From: Contact Centre (CRM) <contact@ribblevalley.gov.uk>
Sent: 19 November 2022 15:06
To: Planning
Subject: Planning Application Comments - 3/2021/0275 FS-Case-466497755

Planning Application Reference No.: 3/2021/0275

Address of Development: Land Behind The Dog Inn Market Place Longridge PR3 3RR

Site Section through The Dog Inn, Plot 2 and 36 Darwen Close

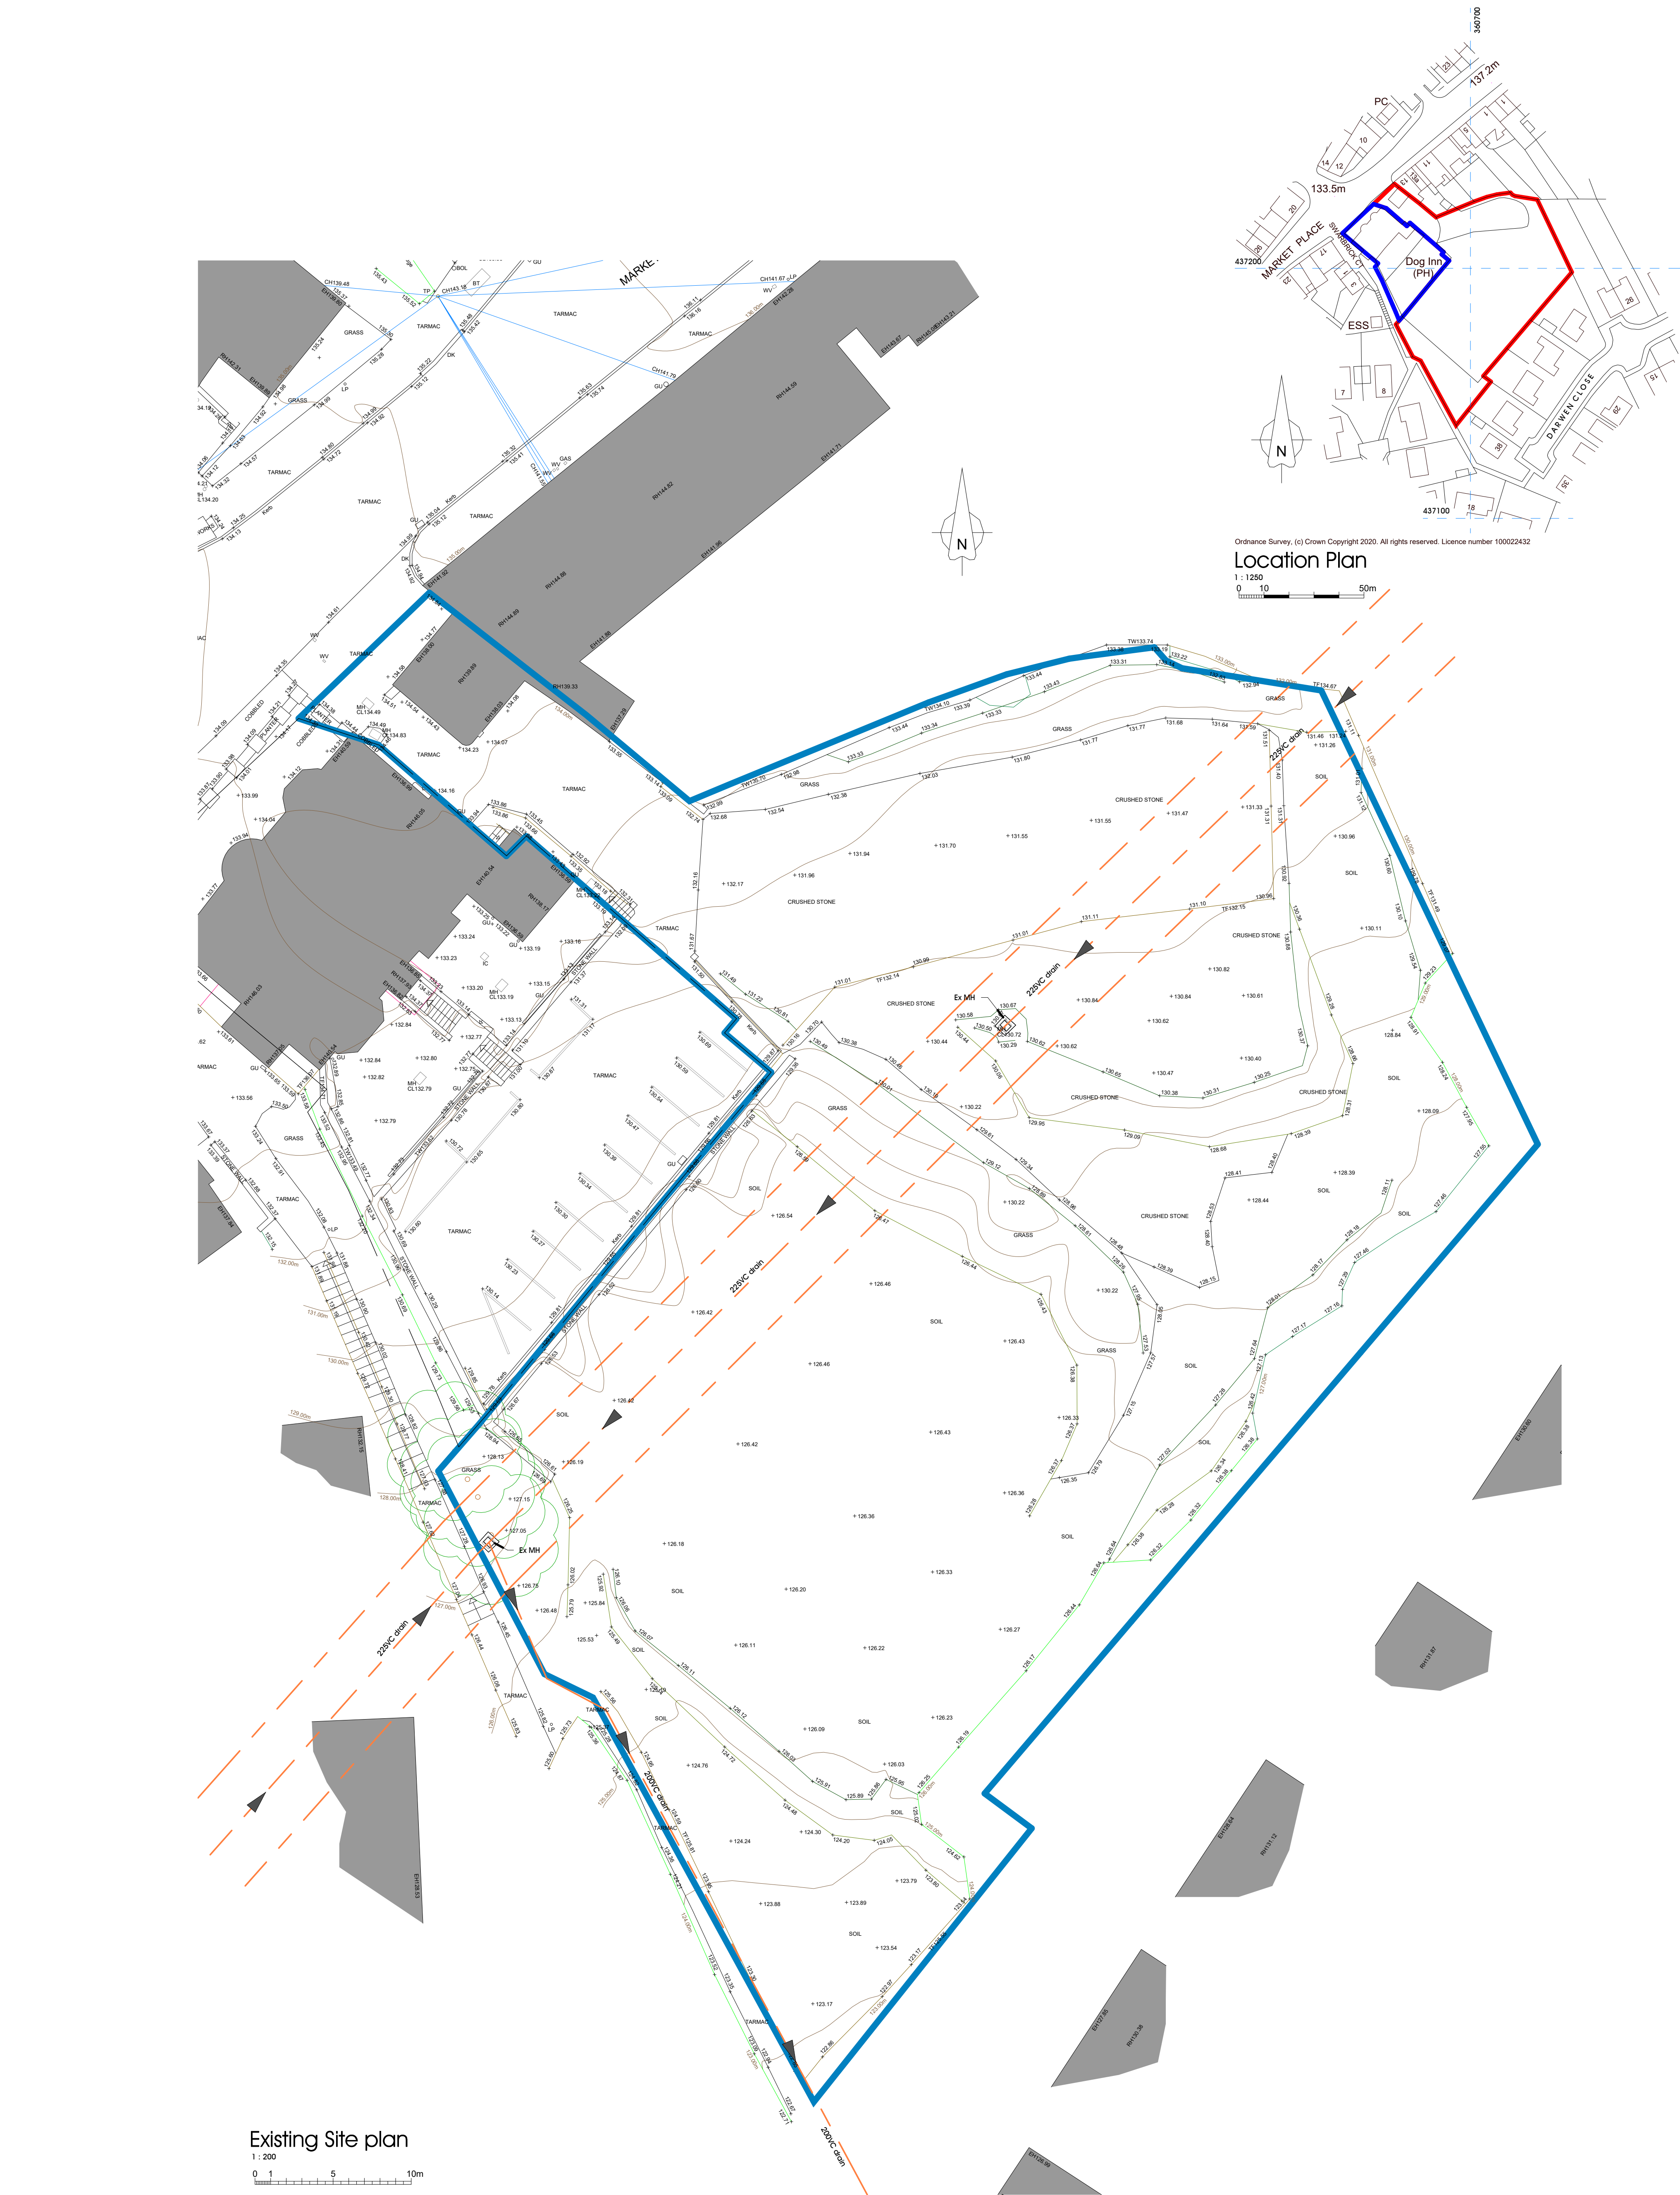
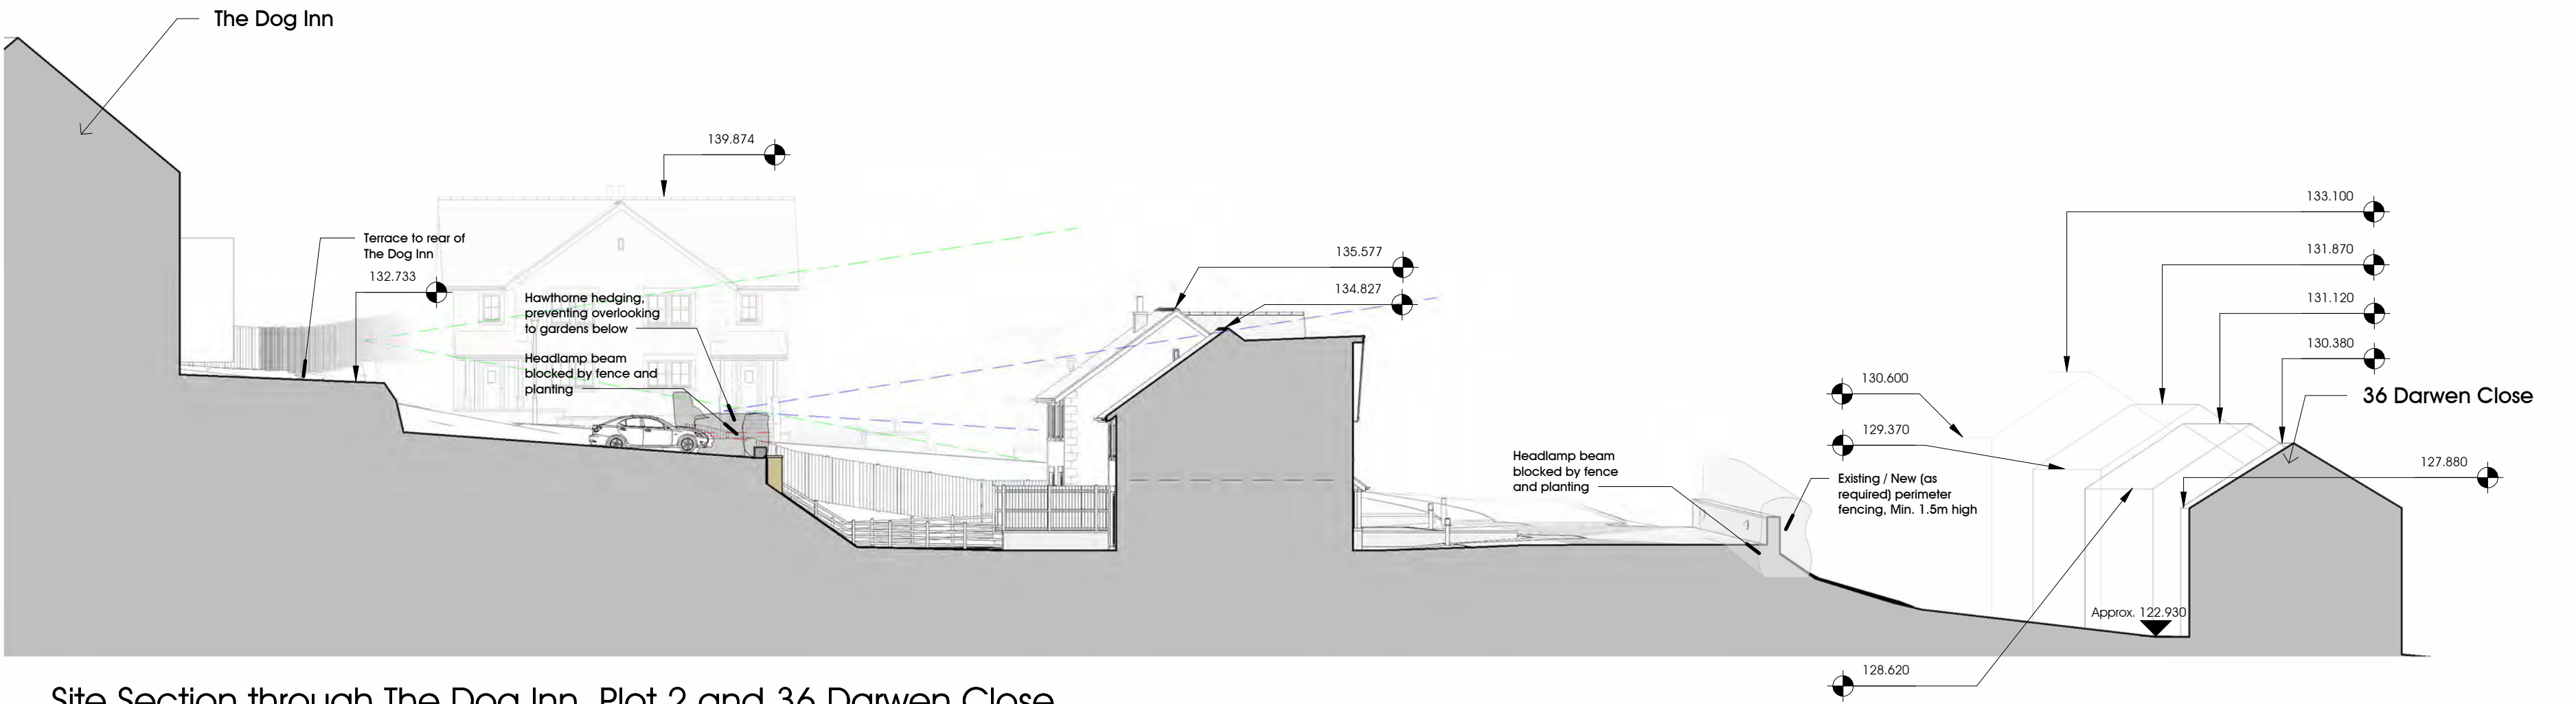
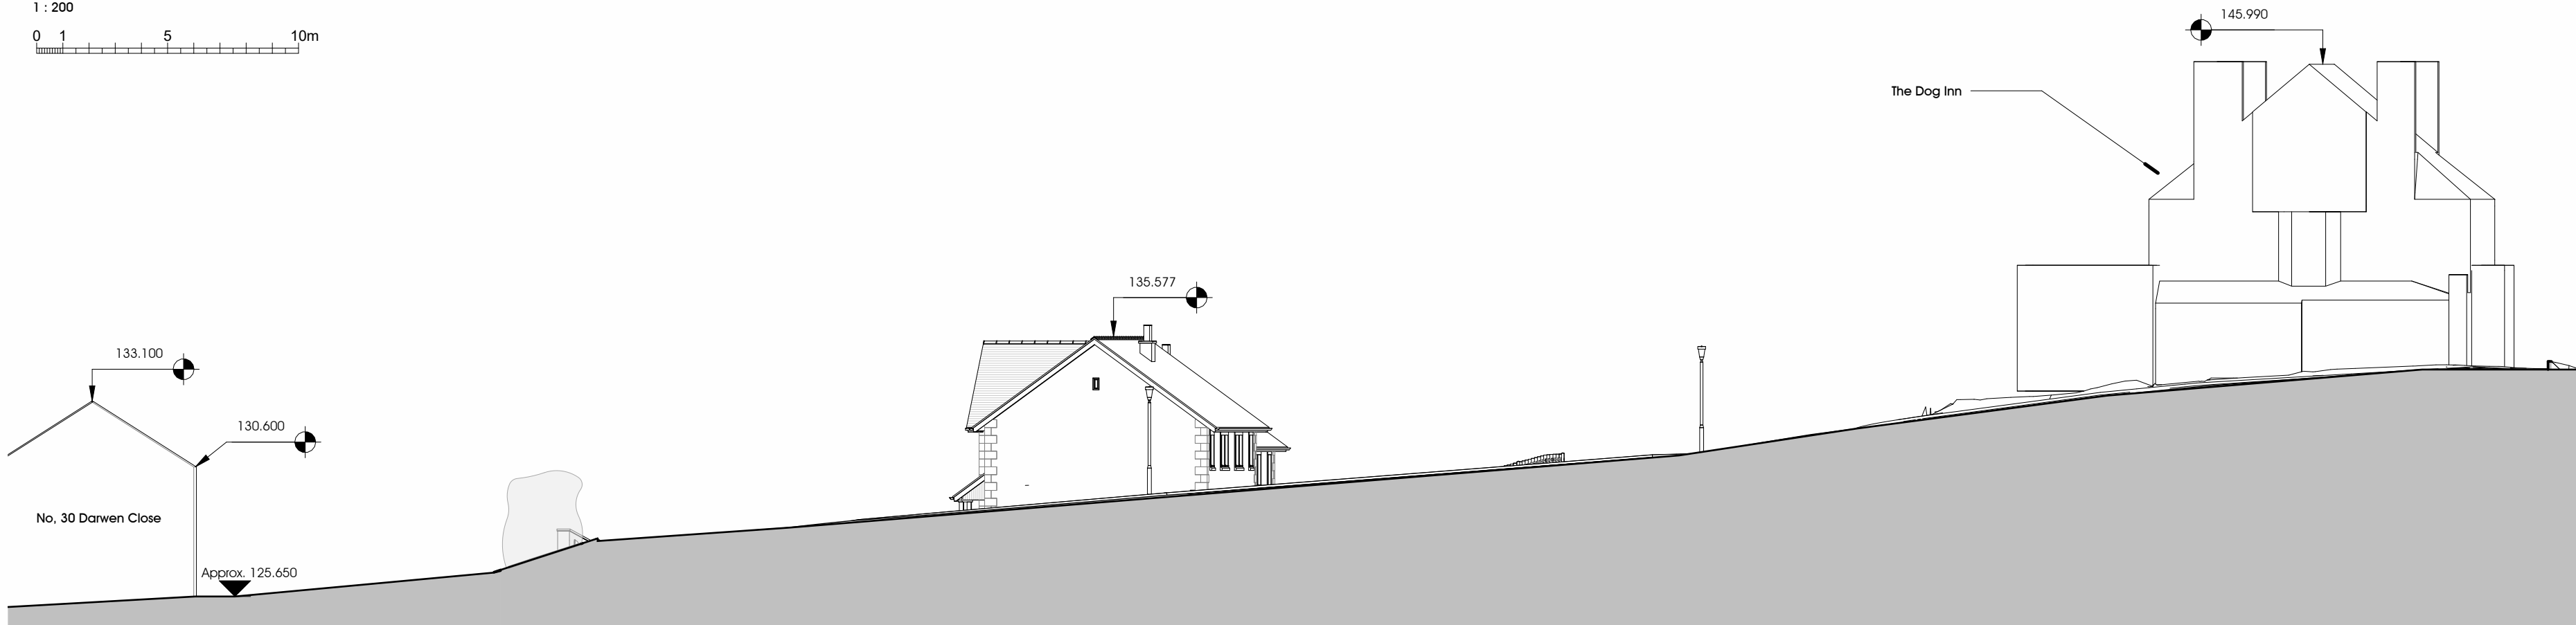
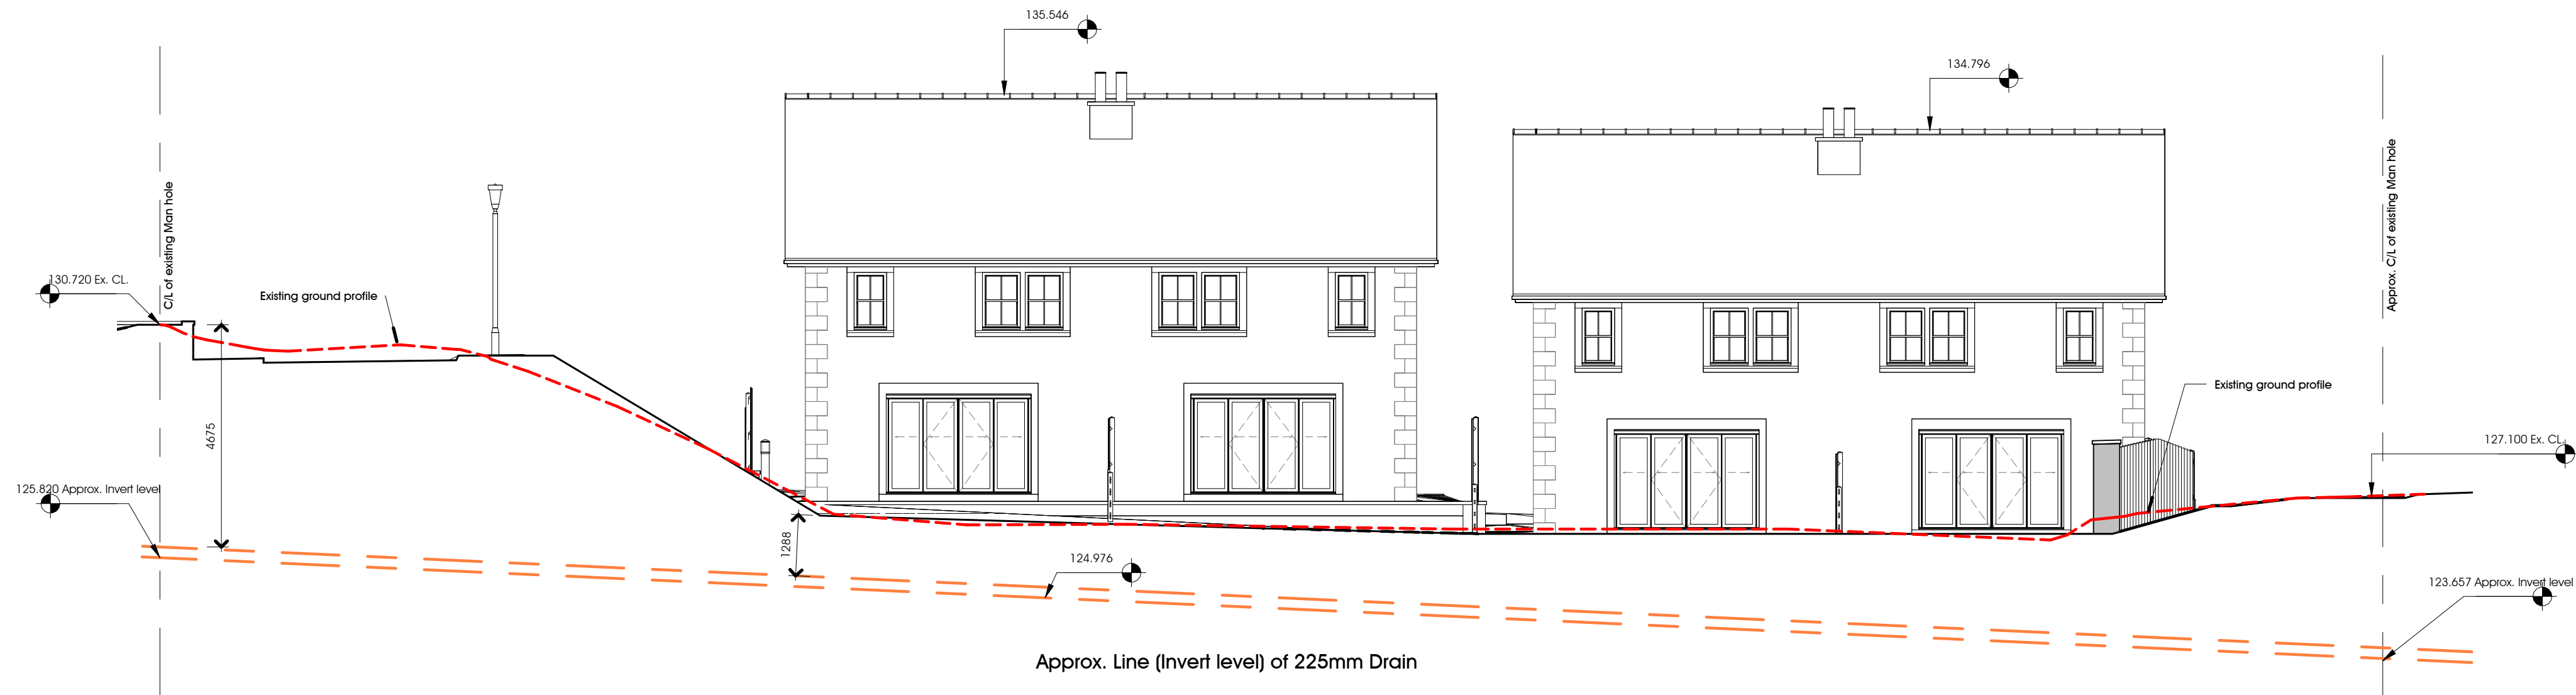
The newest set of plans shows that the development is now going to back almost directly [REDACTED] The house closest (plot 1) will be only 1.5m away and rise 8.5m [REDACTED] effectively cutting out much of the light we currently receive. The photos even show the shadow it casts.
